RE: SSD 6076 – Site 60 | 4 Murray Rose Avenue, Sydney Olympic Park

I refer to the Environmental Assessment for the above SSD Application, which was referred to Sydney Olympic Park Authority (the Authority) for comment on 19 February 2014. The following comments are made on the proposed development, based on issues that the Authority requires further involvement from the applicant.

## The Ledge

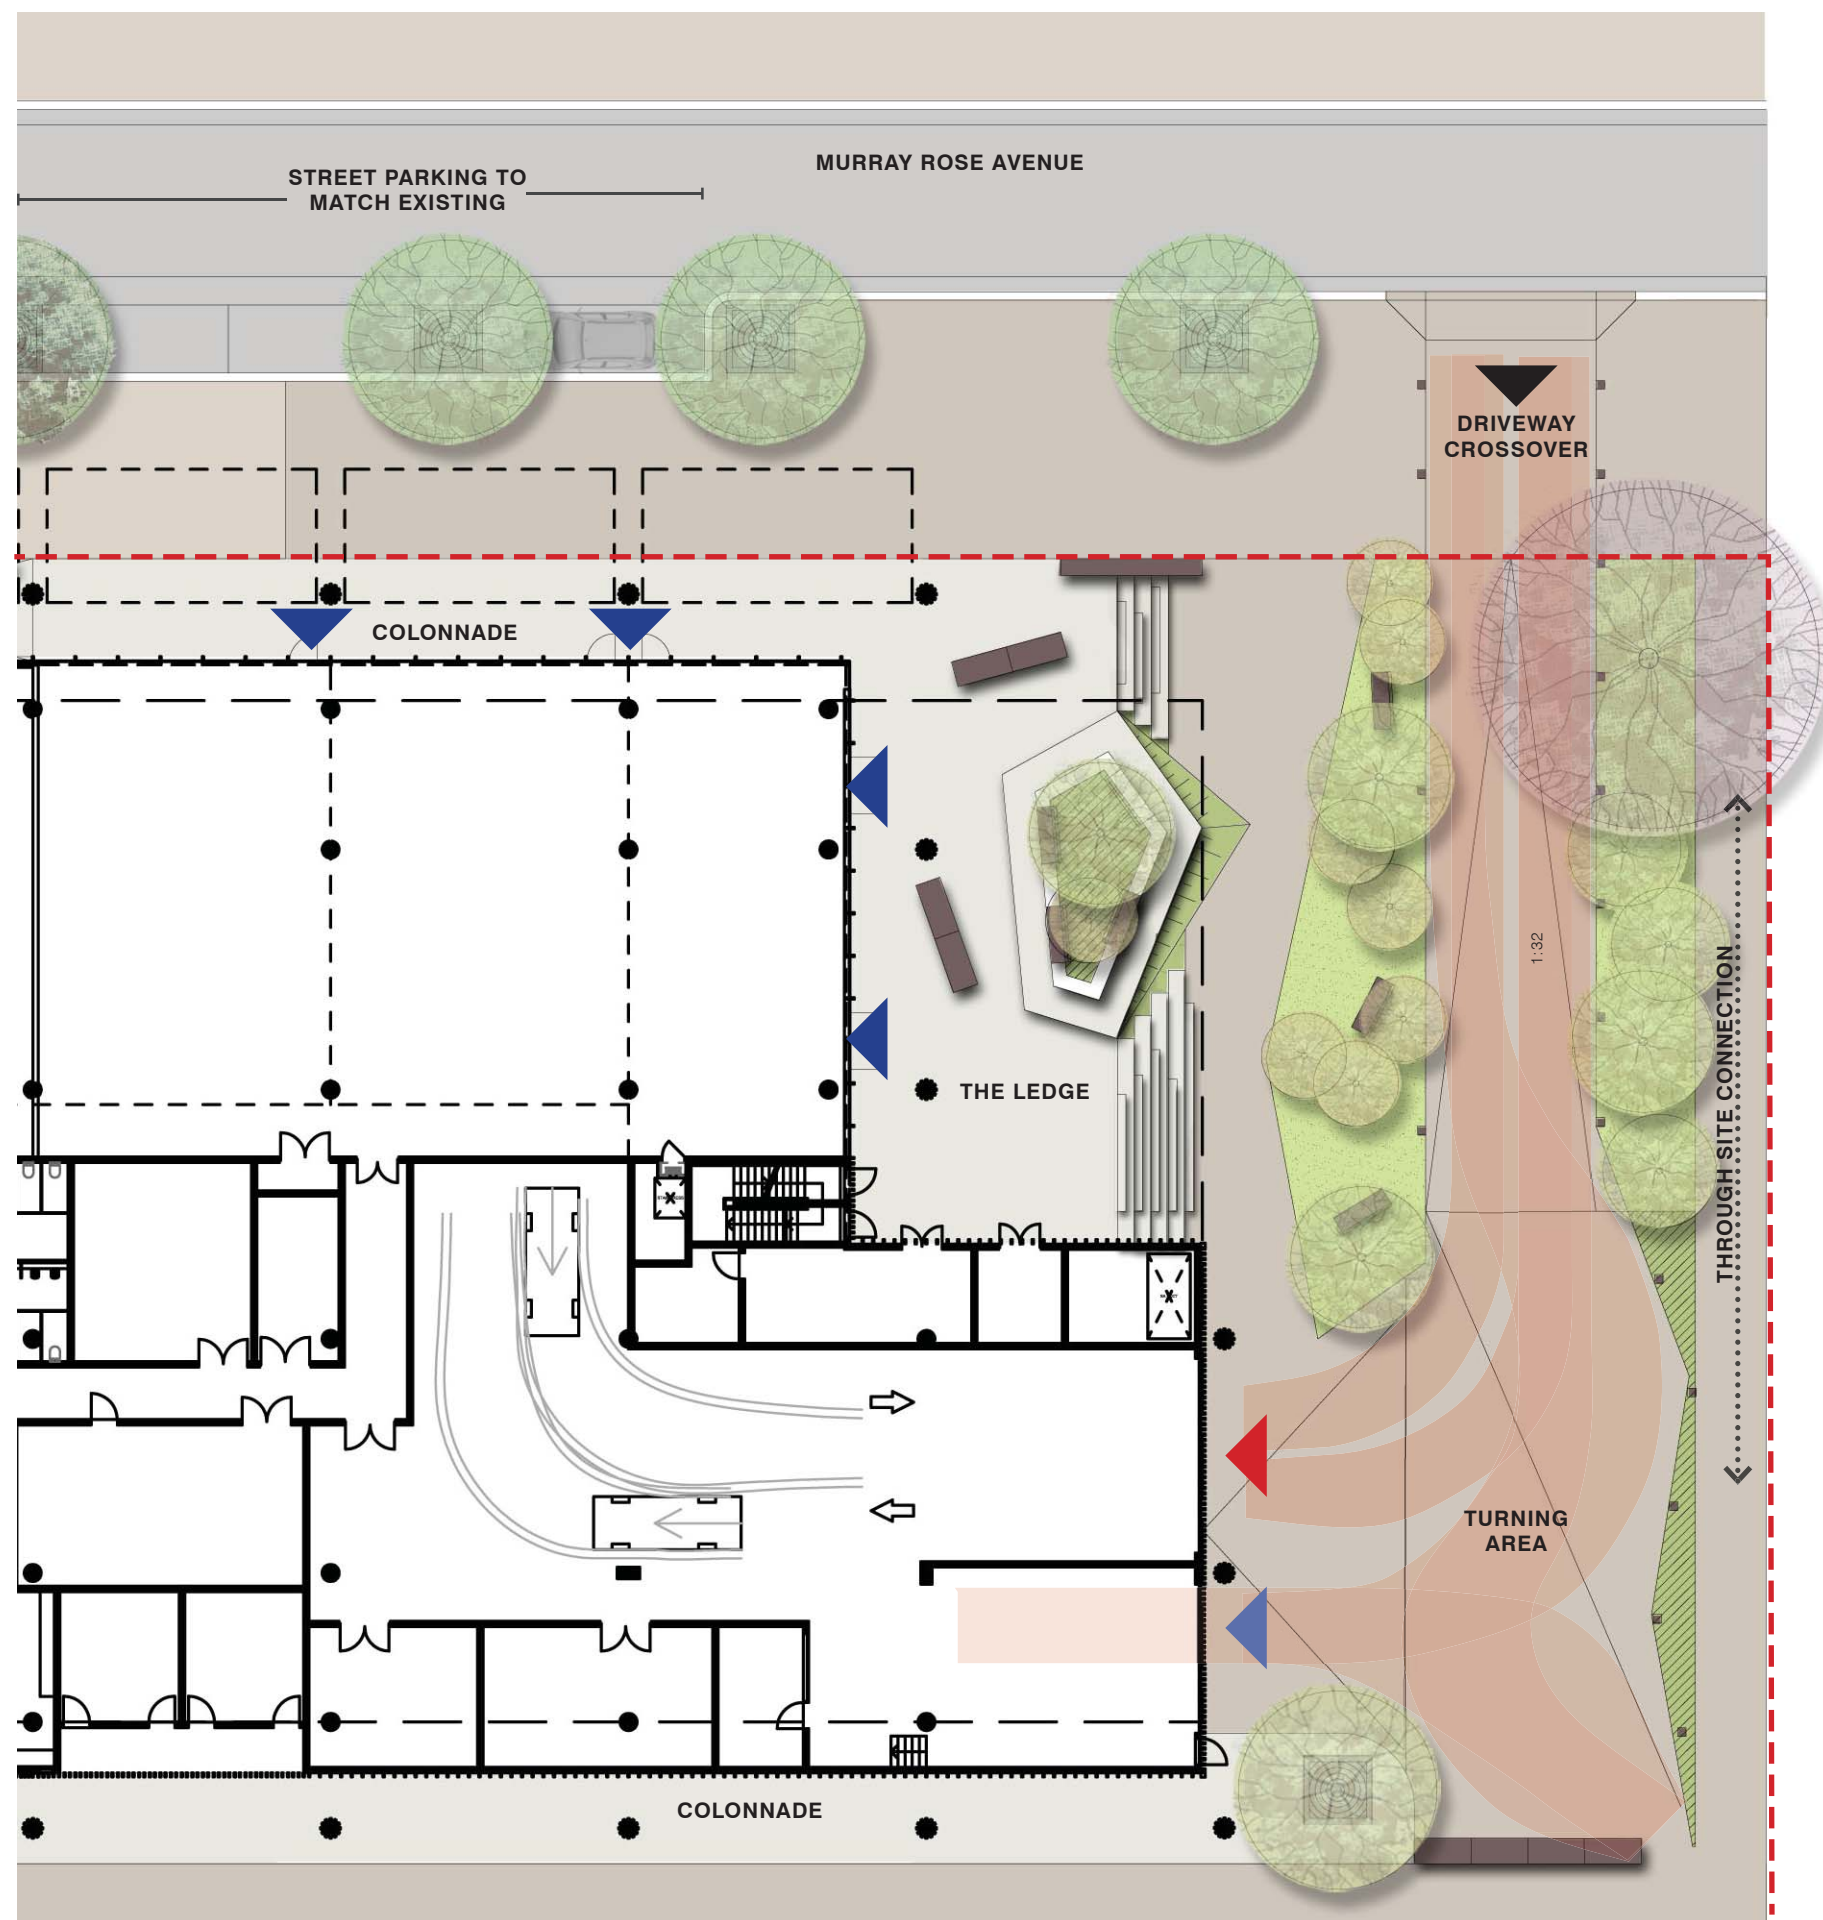
1. 'The Ledge' has trees located over podium/edge of basement with a limited amount of bench and 'bleacher' seating. The external seating should meet the SOPA Access Guidelines and provide backrest and side support. Trees must be provided with adequate 'rootable soil volume' and an automatic irrigation system.
2. The proponent will need to provide details of the pot sizes or detailed species information is provided for proposed planting.

## Paddock Park Future

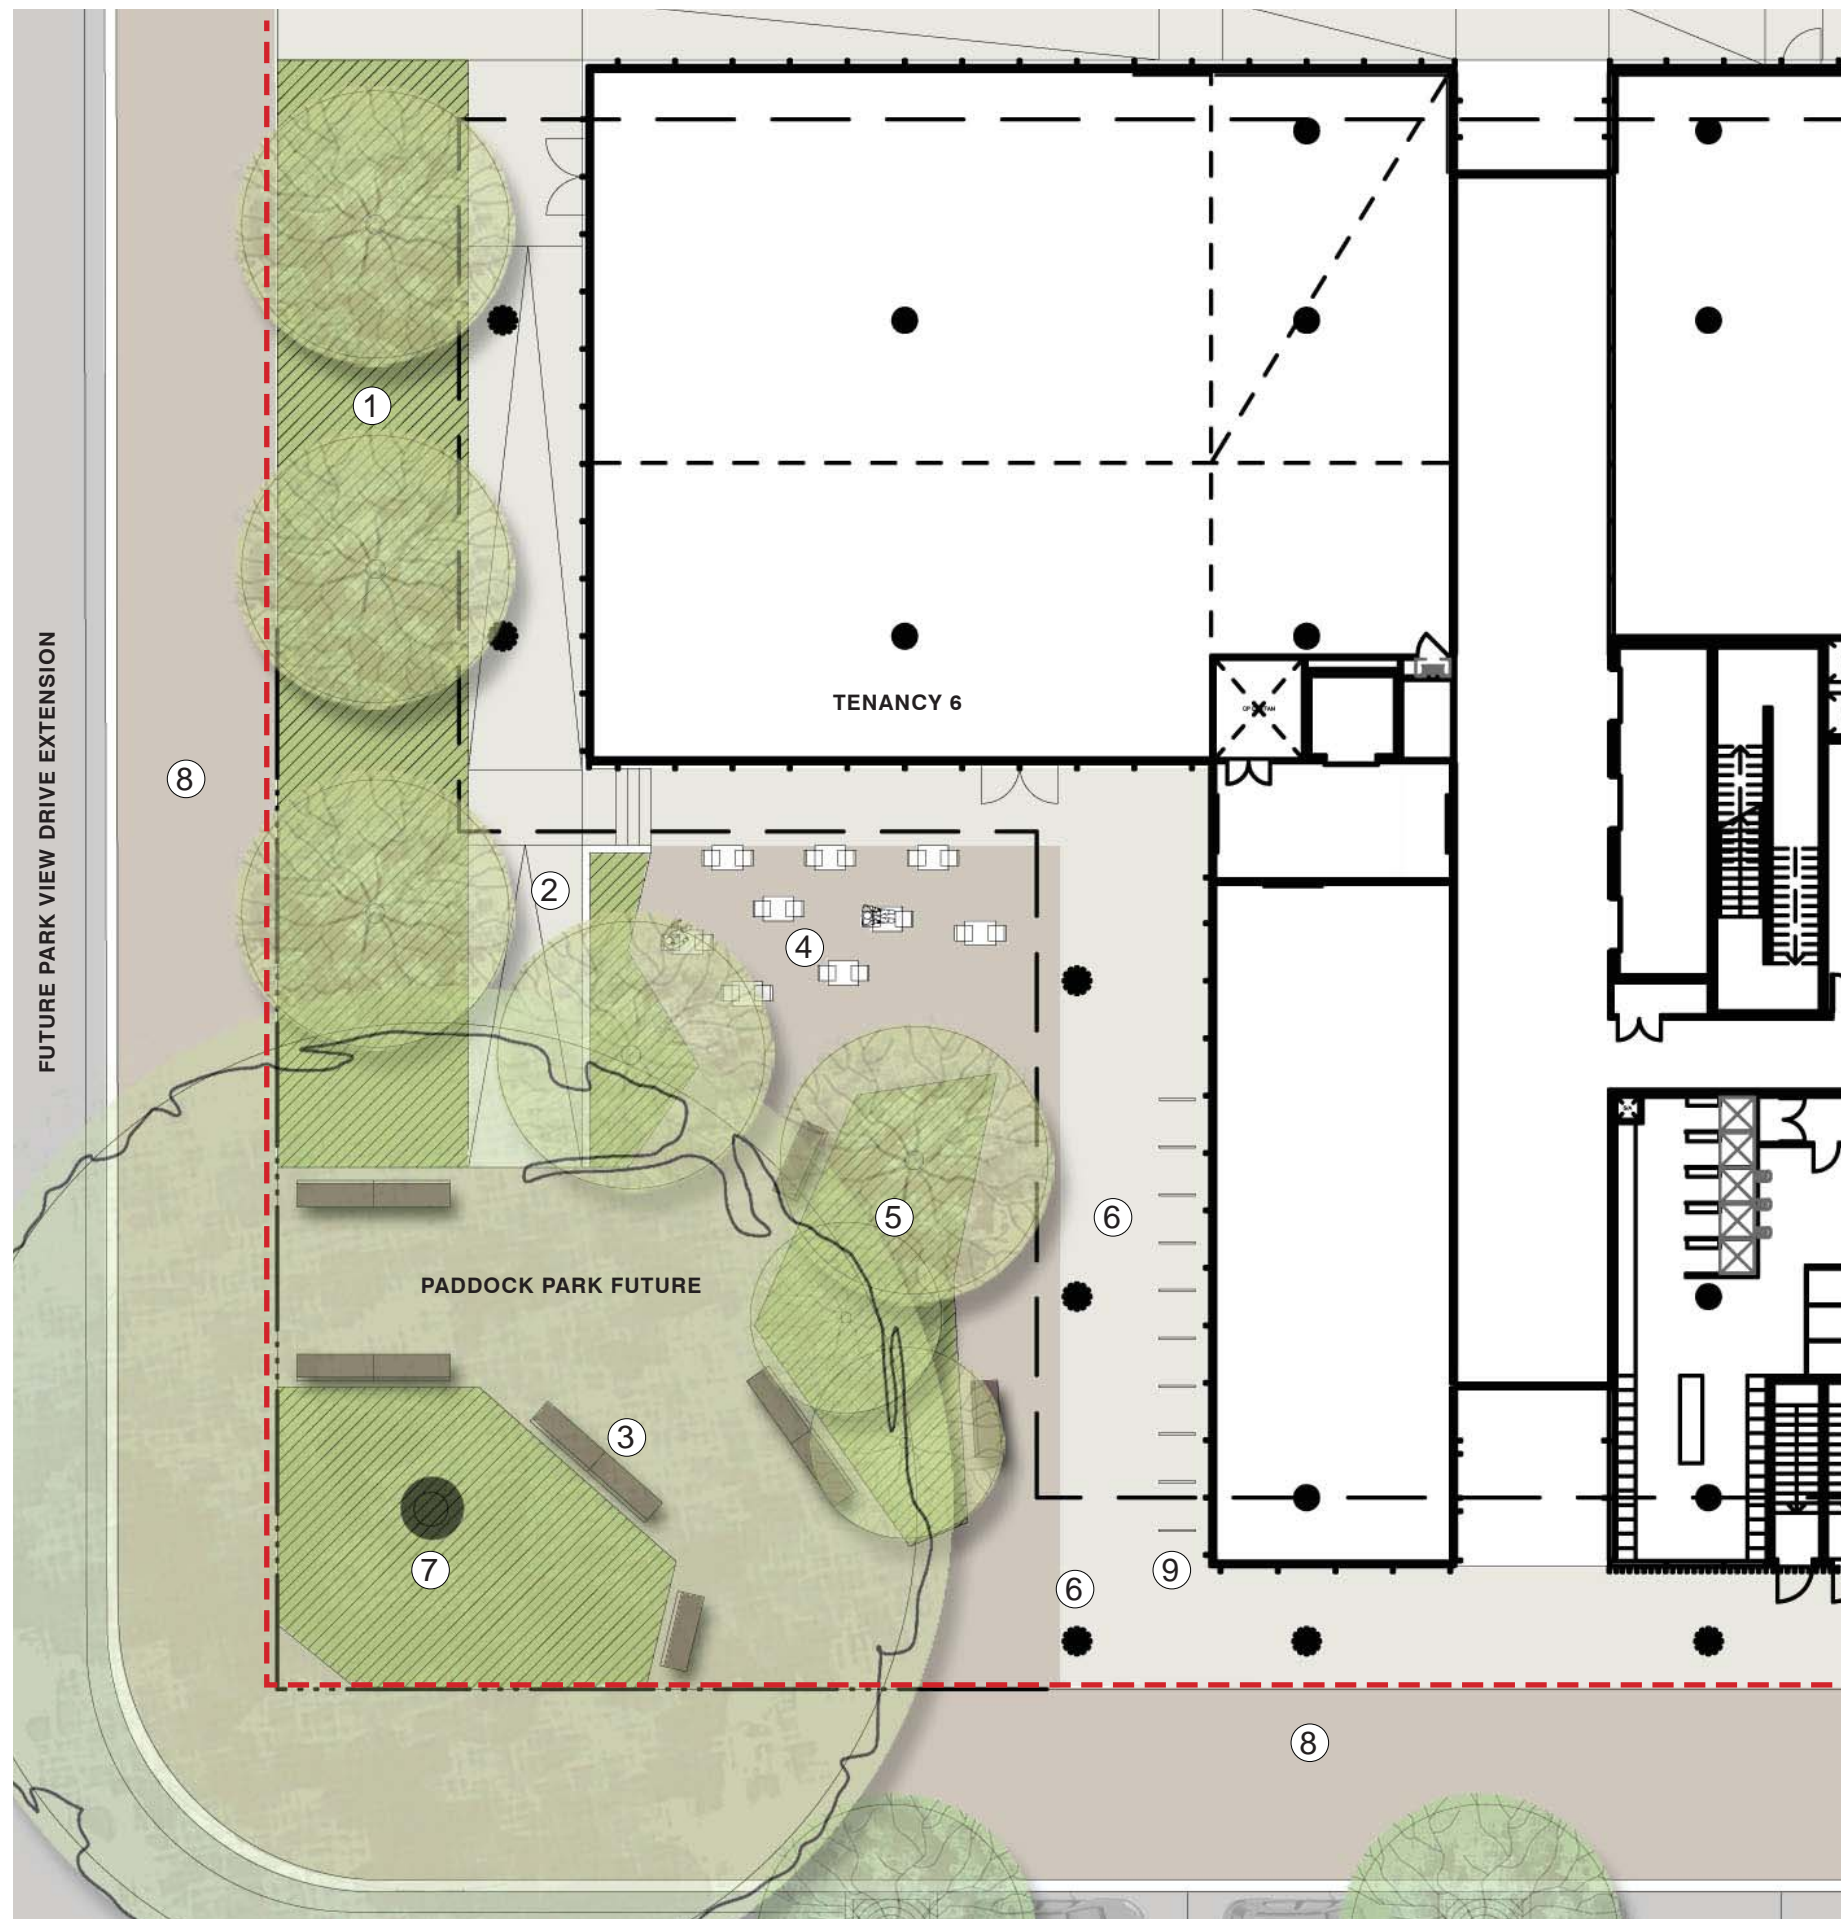
1. The new location of Pocket Park is compromised by the location of 3 exhaust air flues; this is not supported and the structures should be integrated into other parts of the building away from public areas as it will adversely impact on the amenity of this public space and the health / amenity of workers and residents.

2. This space will be used mainly by cyclists to access the Ground Level bicycle store and for visitor bike parking – it is recommended that paving and public seating be provided in this space to offer higher level amenity for users and that the ramp locations be moved away from the 'Tenancy 2' perimeter to allow for better connection of the ground floor tenancy and Pocket Park

3. Pocket Park is more likely to evolve as a pocket urban space rather than a grassed area. Turf is not a suitable surface treatment as this area will be overshadowed for much of the day. The area also has extensive ramping which will need to be DDA compliant.

- Ideally this pocket space could be further activated by complimentary ground floor tenancies such as food & beverage uses, as this area will be a major pedestrian linkage point connecting pedestrian movement between QUAD 4, Brick Pit Park and P6 car park.
